# KITTITAS COUNTY

## DEPARTMENT OF PUBLIC WORKS

### MEMORANDUM

TO: Dusty Pilkington, Community Development Services  
FROM: Kelly Bacon, Engineer Technician I *KB*  
DATE: August 22, 2017  
SUBJECT: Miller BL-17-00012

# MILLERWEBER EXISTING PARCELS

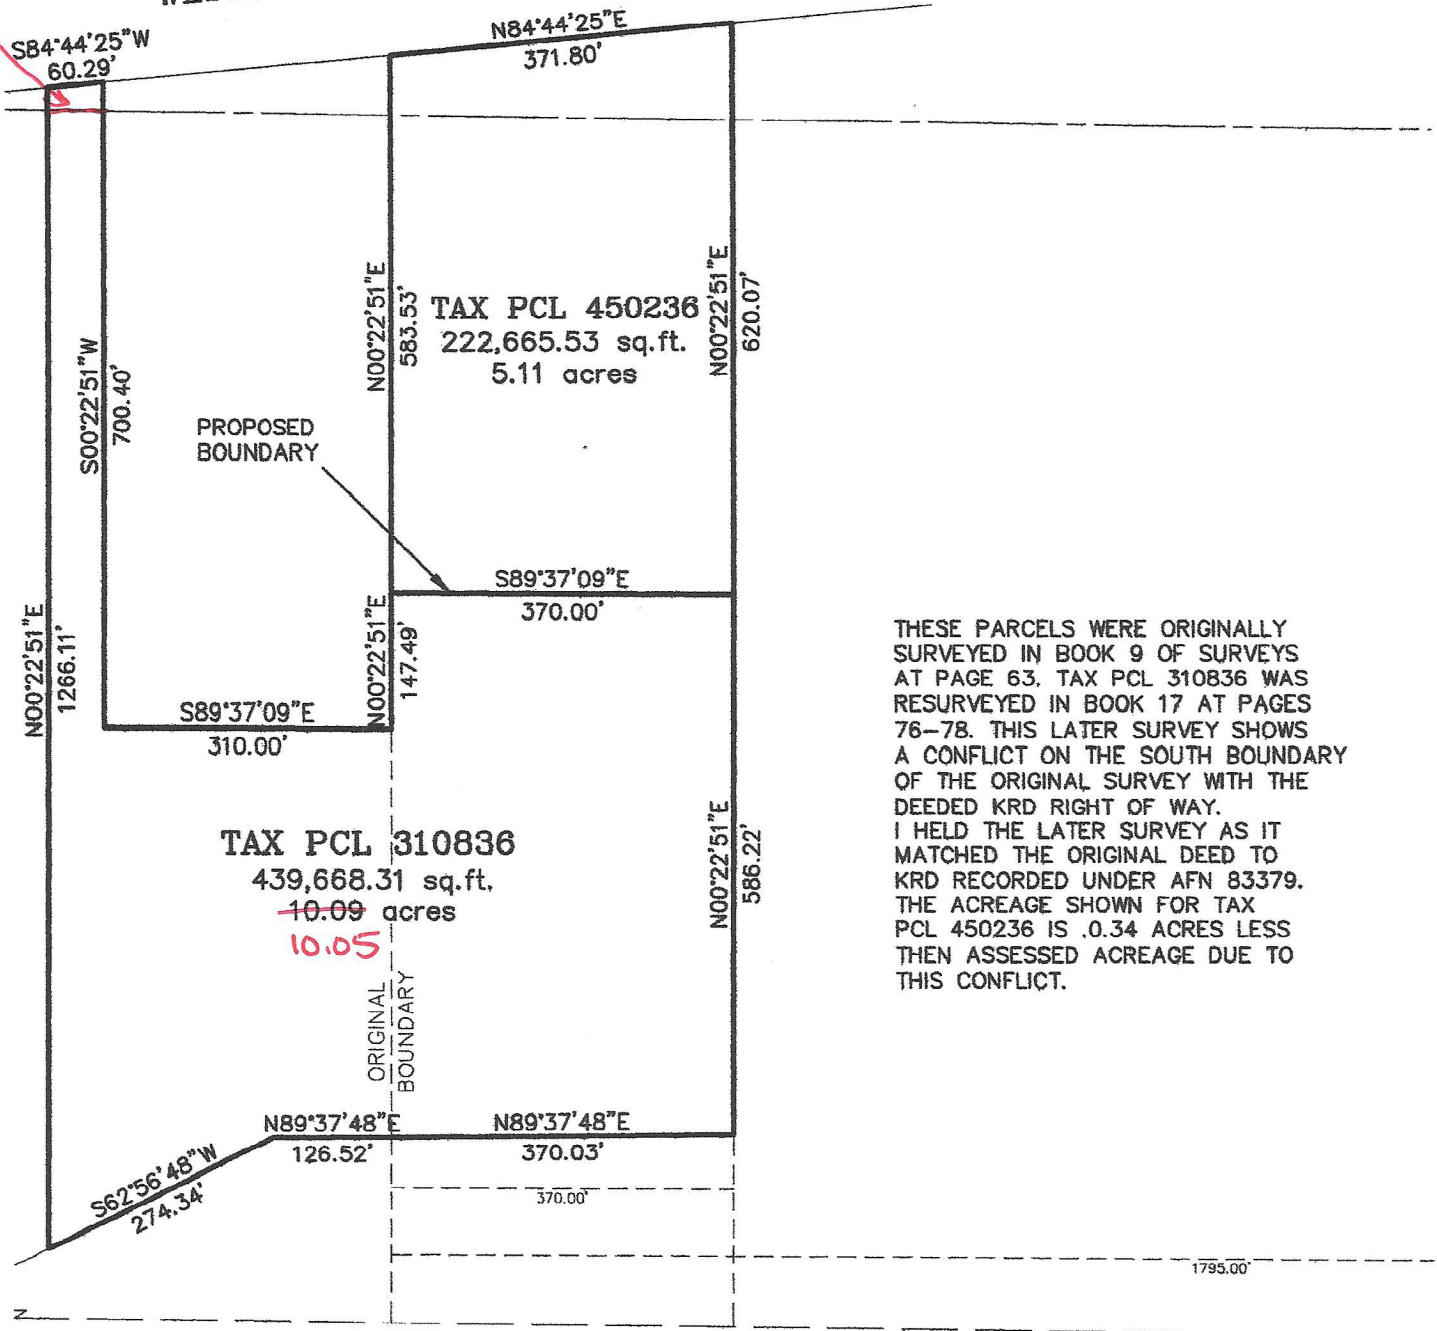
- a. Submit a final survey map for review.
- b. Documentation of the easement to access Parcel 310836 needs to be shown on the face of the survey.
- c. An approved access permit shall be required from the Kittitas County Department of Public Works prior to creating any new driveway access or performing any work within the county road right of way.
- d. Maintenance of driveway approaches shall be the responsibility of the owner whose property they serve. The County will not maintain accesses.
- e. Any further subdivision or lots to be served by proposed access may result in further access requirements. See Kittitas County Road Standards.
- f. Evidence of existing access and/or evidence of access to be created should be confirmed prior to sale of property.
- g. Access is not guaranteed to any existing or created parcel on this application.
